From: [Kelly Bacon \(CD\)](#)
To: [Nick Zito; "kttkelleher@gmail.com"; "Chris Cruse"](#)
Cc: [Jeremy Johnston](#)
Subject: FW: Zito SEPA Comments
Date: Wednesday, November 17, 2021 2:52:46 PM
Attachments: [KZ Freehold SEPA.docx](#)

Subject: FW: Zito SEPA Comments

Thank you for speaking with me this morning regarding Kittitas County SEPA #202105787. Attached above is the letter I received from David Johnson on Monday November 15. The letter alerted me to

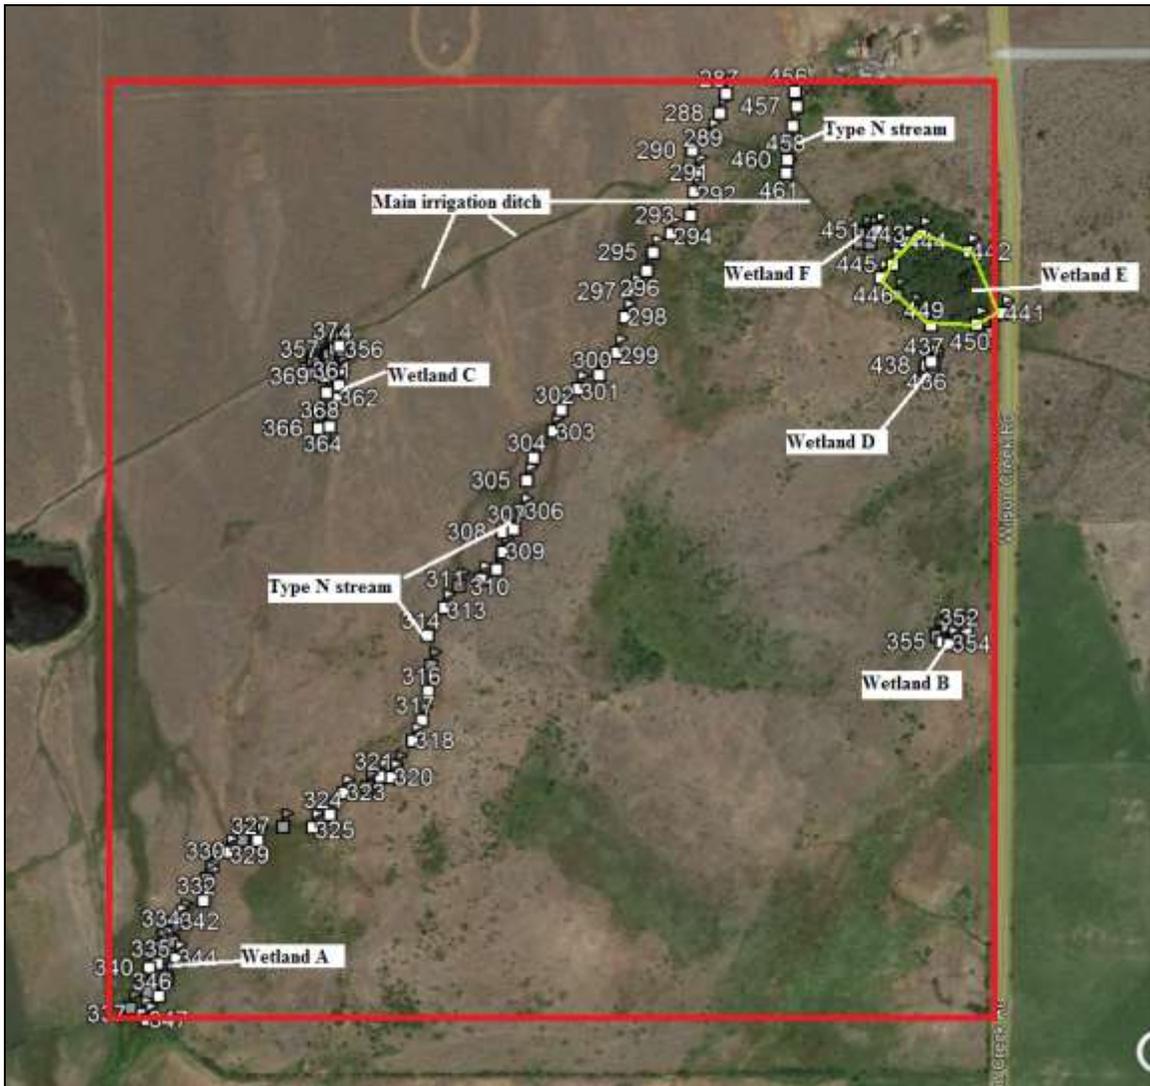
Also located on parcels 18-19-06010-0001 and 19-19-31040-0002 is an intermittent or seasonal stream bed, which runs diagonally from NE to SW through both parcels. This would be the feature referred to as a Class 4 stream bed. The intermittent stream bed is a separate feature from the Haberman ditch, except where the two intersect. At the intersection it appears that a portion of creek bed which lies down-gradient of the Haberman Ditch may have been utilized to convey irrigation water at some time in the past. This may have been the Jo Bar Two Land & Cattle LLC turnout, and perhaps this is the channel the SEPA checklist refers to as abandoned(?). In either case, the USGS Quadrangle clearly shows a portion of the Haberman ditch, an attached pond, and the intermittent stream bed as three separate features, all of which are verified on the 2019 aerial photographs (attached above).

Given the insufficient nature of the information provided on the SEPA checklist, I request that the checklist be revised to acknowledge that the Haberman ditch runs across parcel 19-19-31040-0002 and is actively maintained by at least one water right holder. Water right holders hold prescriptive easement to utilize and maintain existing ditches. All property owners that hold water rights associated with the Haberman ditch should be duly informed of the revision and provided a chance to comment on their own behalf.
